Engineers Comments Regarding Surface Water Drainage

Application No: AL/43/20/DOC

Site Address: 2 Tudor Cottages Tudor Drive Westergate Aldingbourne PO20 3YT
Description of Works: Approval of details reserved by condition imposed under ref AL/77/19/HH relating to Condition No 3 - surface water drainage

**Construction
Details
scale 1:25**

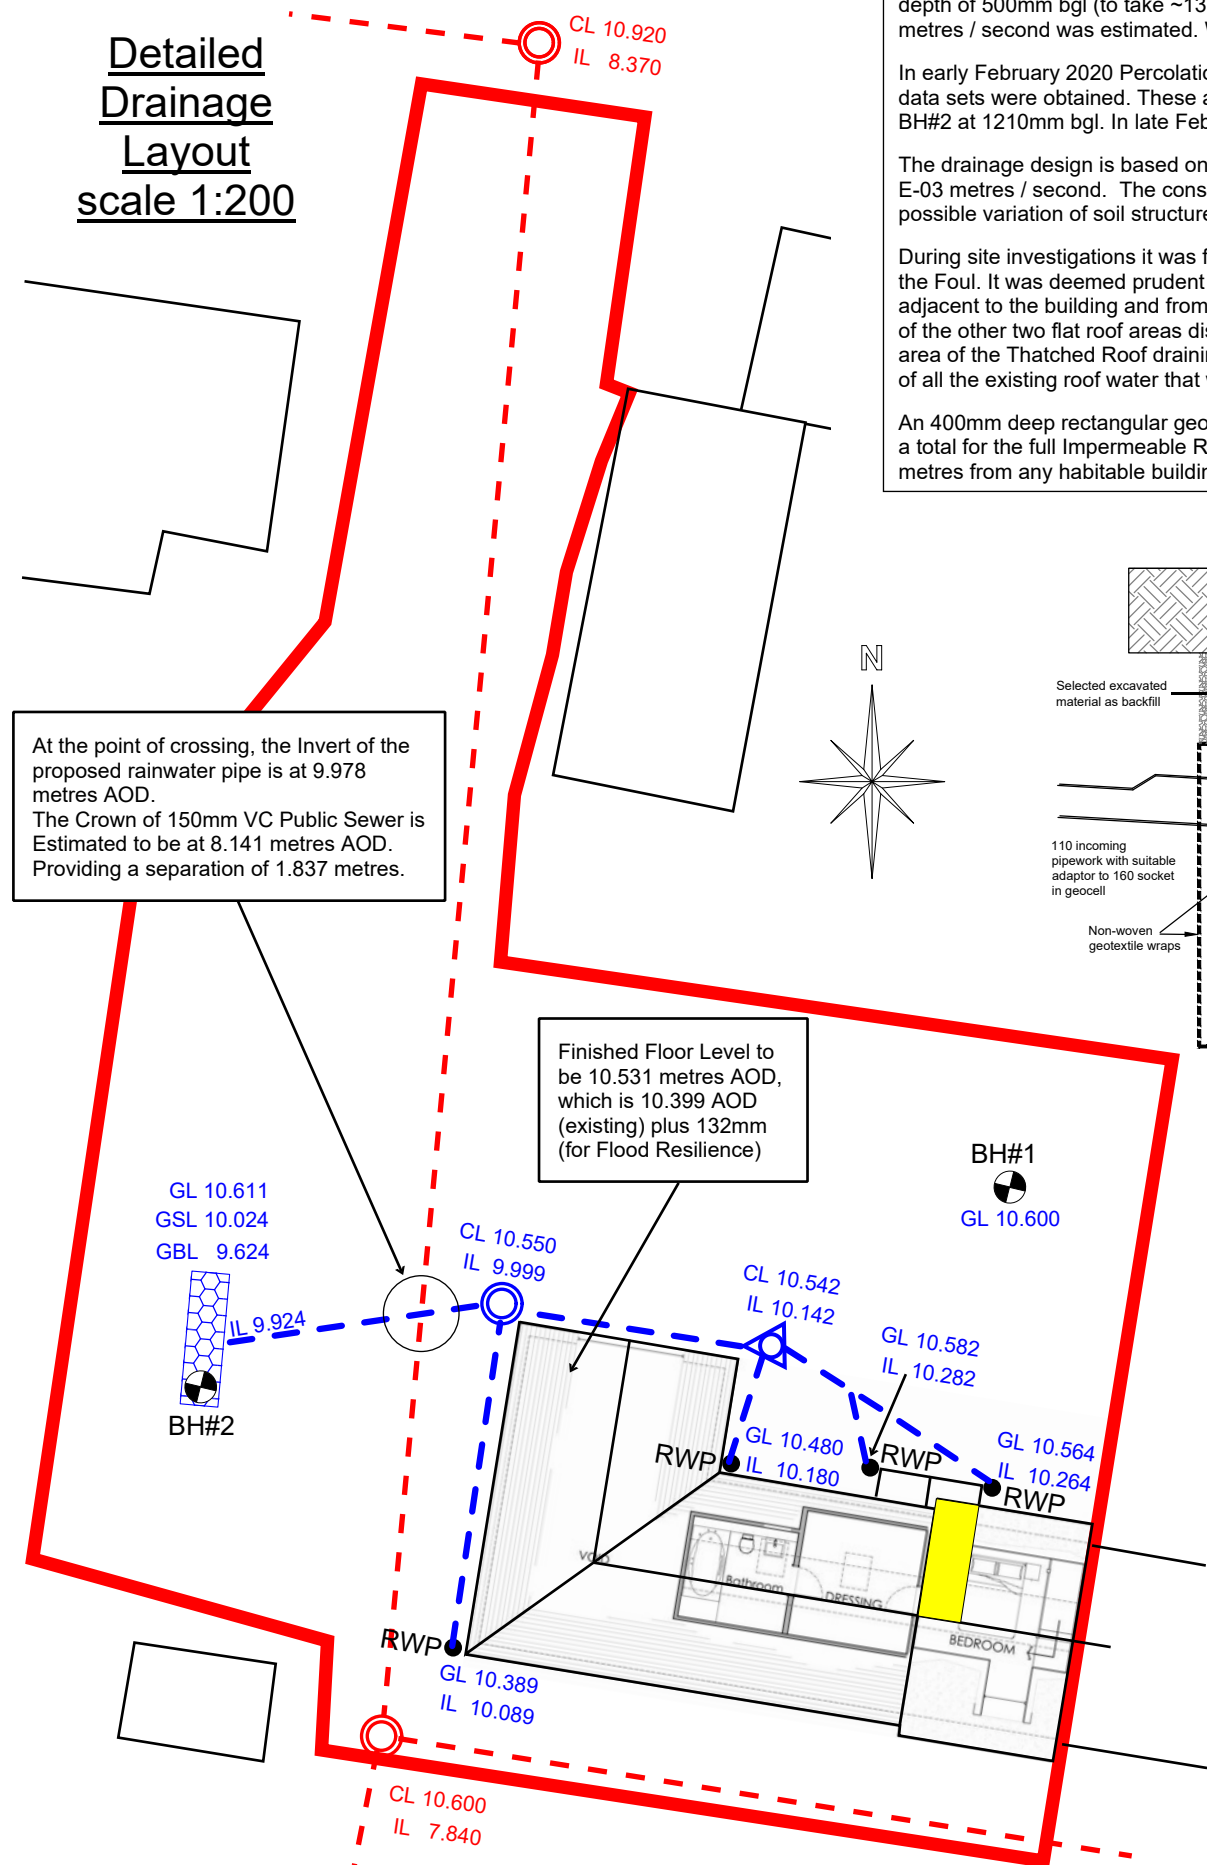
1. Please provide a construction detail for a concrete pipe bed and surround for where pipe depths are less than 900mm. Plus amend note as to when each surround should be used (Granular where cover to crown is greater than 1200mm in vehicular areas, or greater than 900mm elsewhere. For shallower depths concrete surround.)
2. Please provide a construction detail for the inspection chamber (no sump).
